RE: Range Short Plat, File #SP-07-13

The Kittitas County Community Development Services Department has determined that the Range Short Plat is a complete application and hereby grants **conditional** preliminary approval subject to the following conditions:

DWN. BY	KJW	DATE	12/26/06	JOB NO.	00731.021
DKD. BY	JMB	SCALE	VARIABLE	SHEET	2 OF 2

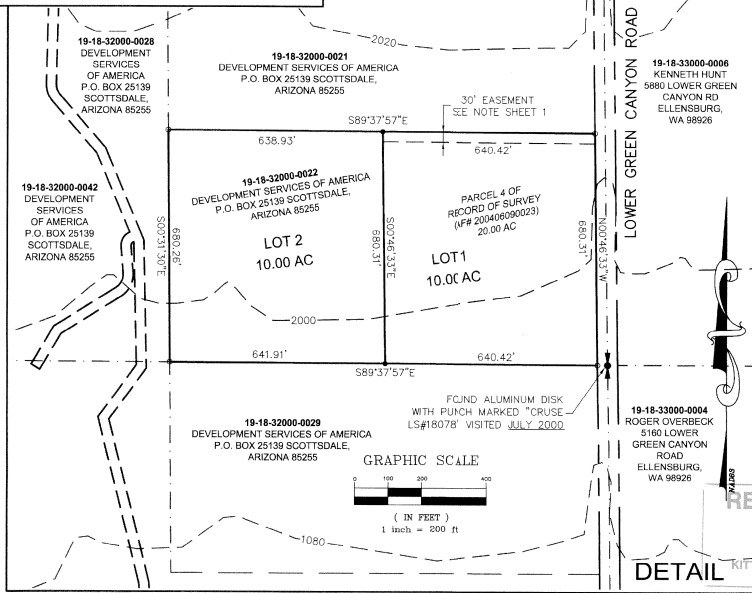
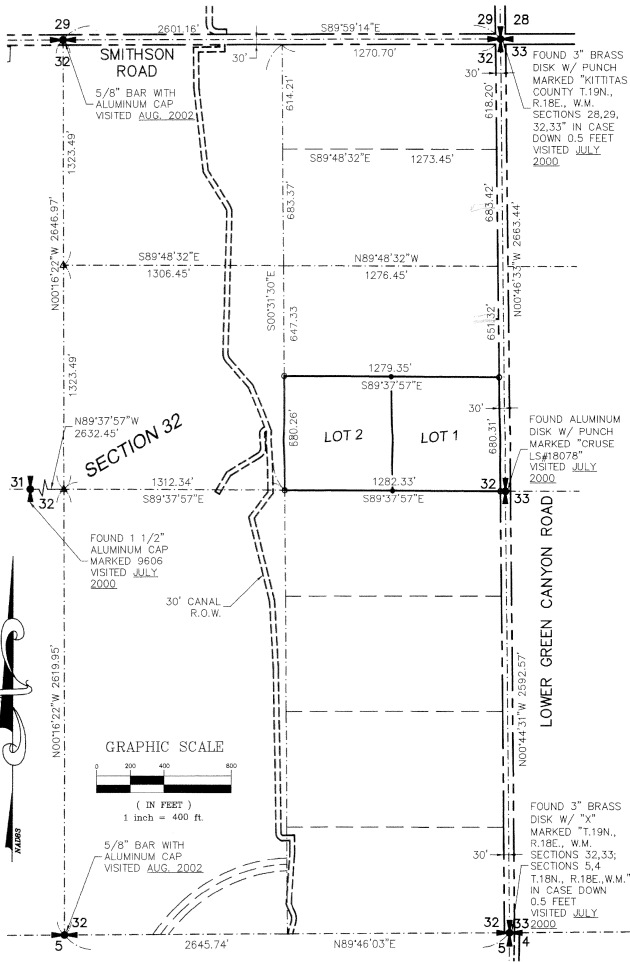
3. Page one shall reflect the short plat map.
4. A statement regarding the contemplated sewage disposal, water supply, and drainage improvements for the proposed subdivision shall be reflected on the final mylars.

5. Vicinity map showing the boundary lines of all adjacent subdivisions shall be reflected on the final mylars.
6. This property is within the boundaries of the KRD and both parcels contain irrigable ground. The applicant will need to comply with the requirements set forth in the KRD General Guidelines prior to approval from KRD and prior to final approval of the short plat.

10. Both lots of the Range Short Plat has a PEMC wetland across the west end of the property. The Final mylars shall reflect the location of this wetland and a statement on the plat shall read as follows: "Future development of lots may require a study by a certified wetland biologist to determine wetland classification and for buffer requirements pursuant to KCC Critical Areas Code."
